M25 junction 28 improvement scheme

9.34 Applicant's comments on Local Impact Report submitted by London Borough of Havering

Rule Number:	Rule 8 (1) (j)
Planning Inspectorate Scheme Reference	TR010029
Application Document Reference	TR010029/EXAM/9.34
Author:	M25 junction 28 scheme, Project Team, Highways England

Version	Date	Status of Version
0	18 February 2021	Deadline 3a

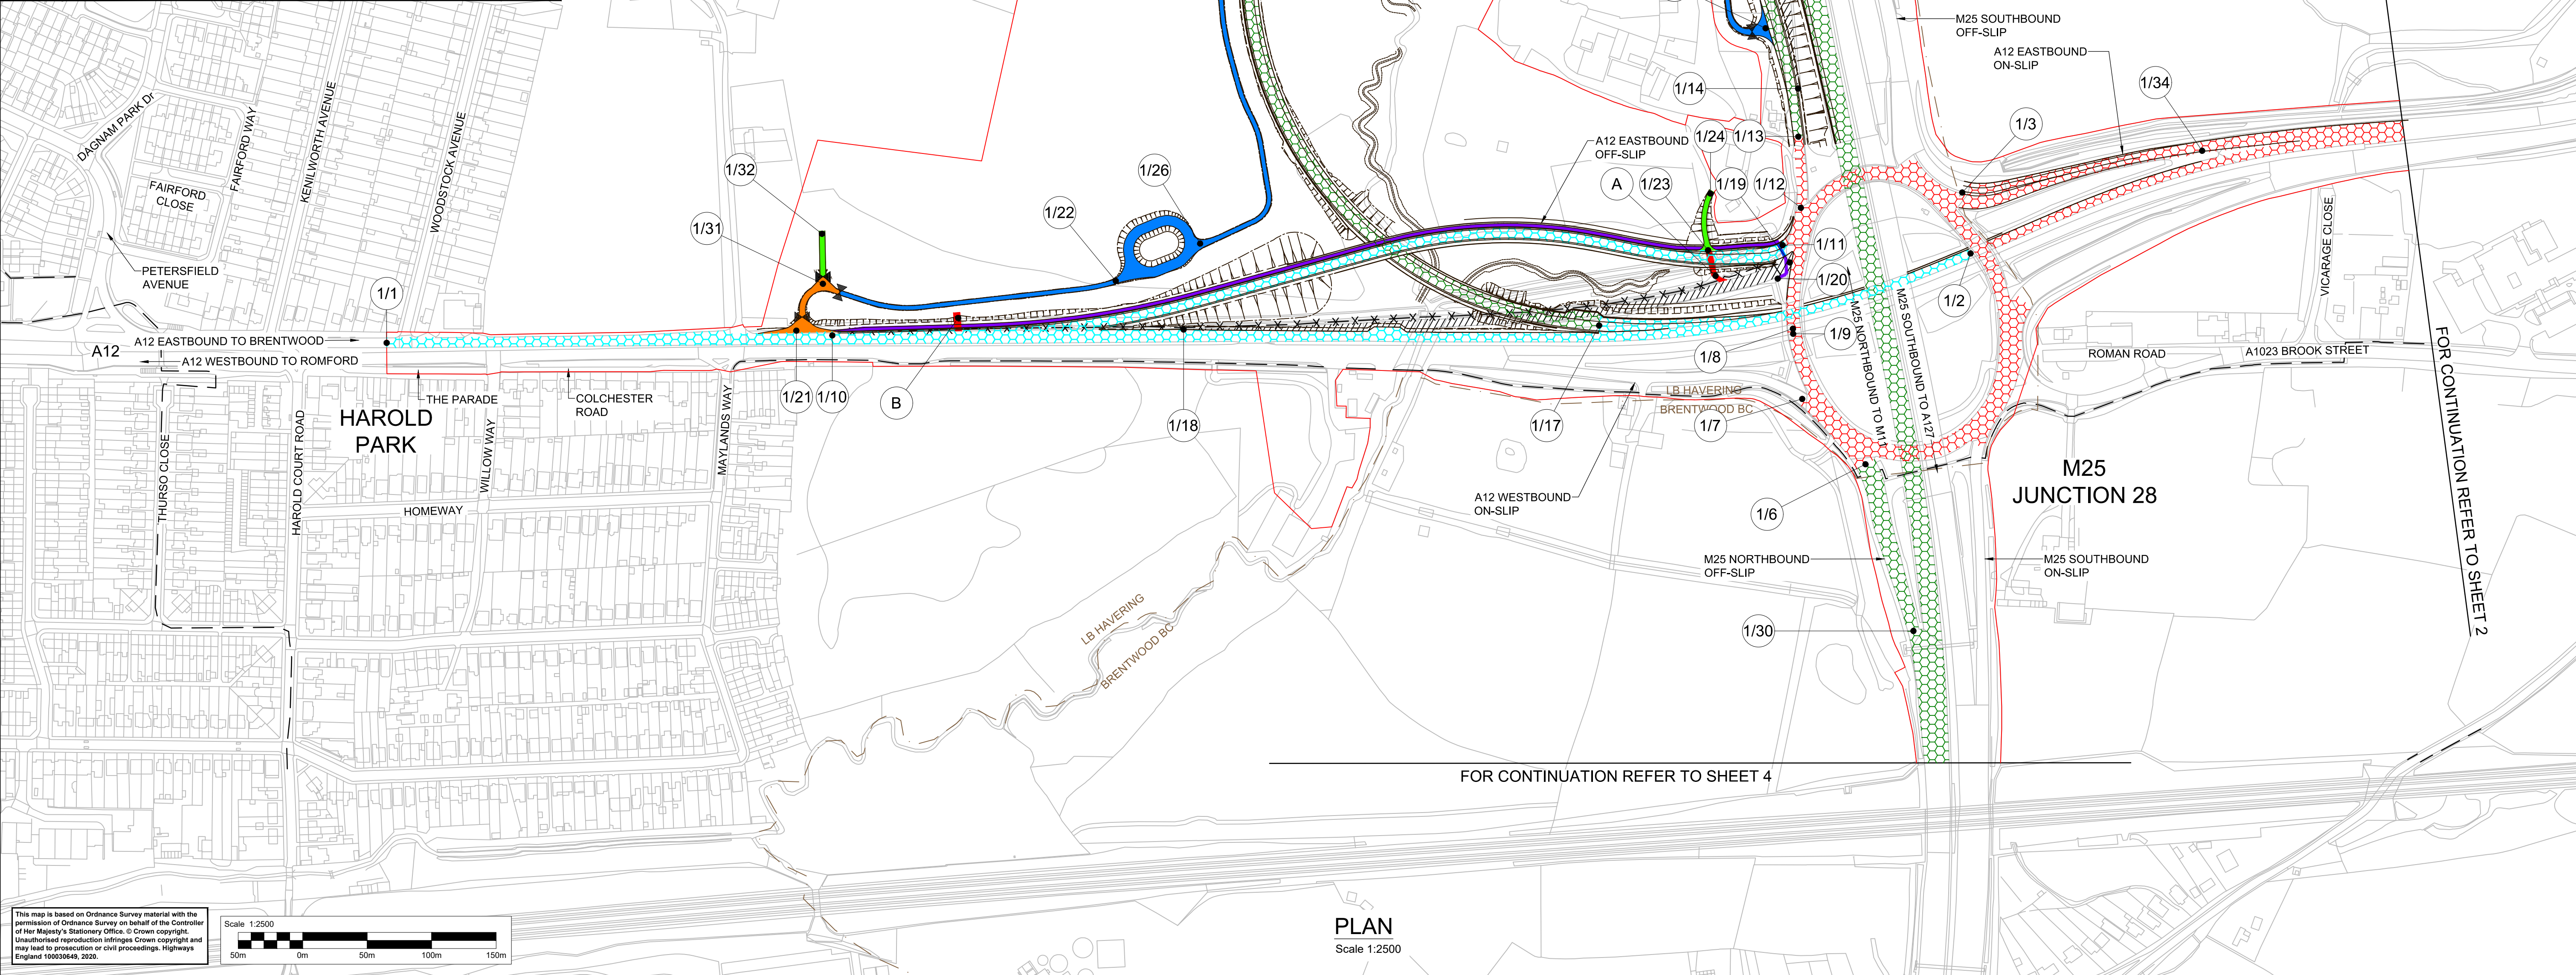
Chapter 17 Non-Motorised Users		
17.1.4 to 17.1.5	<p>Regarding Non-Motorised Users (NMU), paragraph 17.1.4 to 17.1.5 state: <i>The creation of the new right of way alongside the A12 as Work No 2 (i.e. a roadside footpath) is marked on TR010029 2.4 Streets, rights of way and access plans, plan No 1 from location 1/10 to 1/20 but then does not appear to connect to a right way around the Brook Street roundabout (from point 1/20 southwards to point 1/7) to the footpath right of way that runs along the southern section of the A12, along the west bound on-slip, across the southern section of the J28 gyratory and then into Brook Street. This creates a situation for users of no safe route being available under the scheme from the northern side of the A12 west of the junction to the footpath on Brook Street towards Brentwood. This places users of the footpath network in this section of the borough at risk.</i></p> <p><i>Notwithstanding the above the dDCO passes responsibility for seeking closures of public and private rights of ways on a temporary basis to the contractor – dDCO Clause 13(1)(b). Along with the temporary highway closure powers discussed elsewhere in the LIR this is, as matter of principle, unacceptable to LB Havering. The local highway authority expects the scheme promoter to deal with such matters. LB Havering also notes that rights of way within the highway will be subject to the same unacceptable regime.</i></p>	<p>At present, pedestrians and cyclists are able to cross the Brook Street roundabout via a footway leading along the northern side of the A12 off-slip, cross to the inside of the Brook Street roundabout at the end of the A12 eastbound off-slip road and cross again at the A12 westbound on-slip. It is then possible to cross the M25 northbound off-slip, pass under the M25 and cross the M25 southbound on-slip to reach Brook Street. The Scheme includes a replacement footway to the north side of the A12 off-slip which would tie in with the existing footpath on the inside of Brook Street. As such the Scheme retains the facilities for pedestrians and cyclists</p> <p>In regard to the concern with dDCO Clause 13(1)(b), please see the response to paragraph 24.1.6 Clause 13 later in this document.</p>
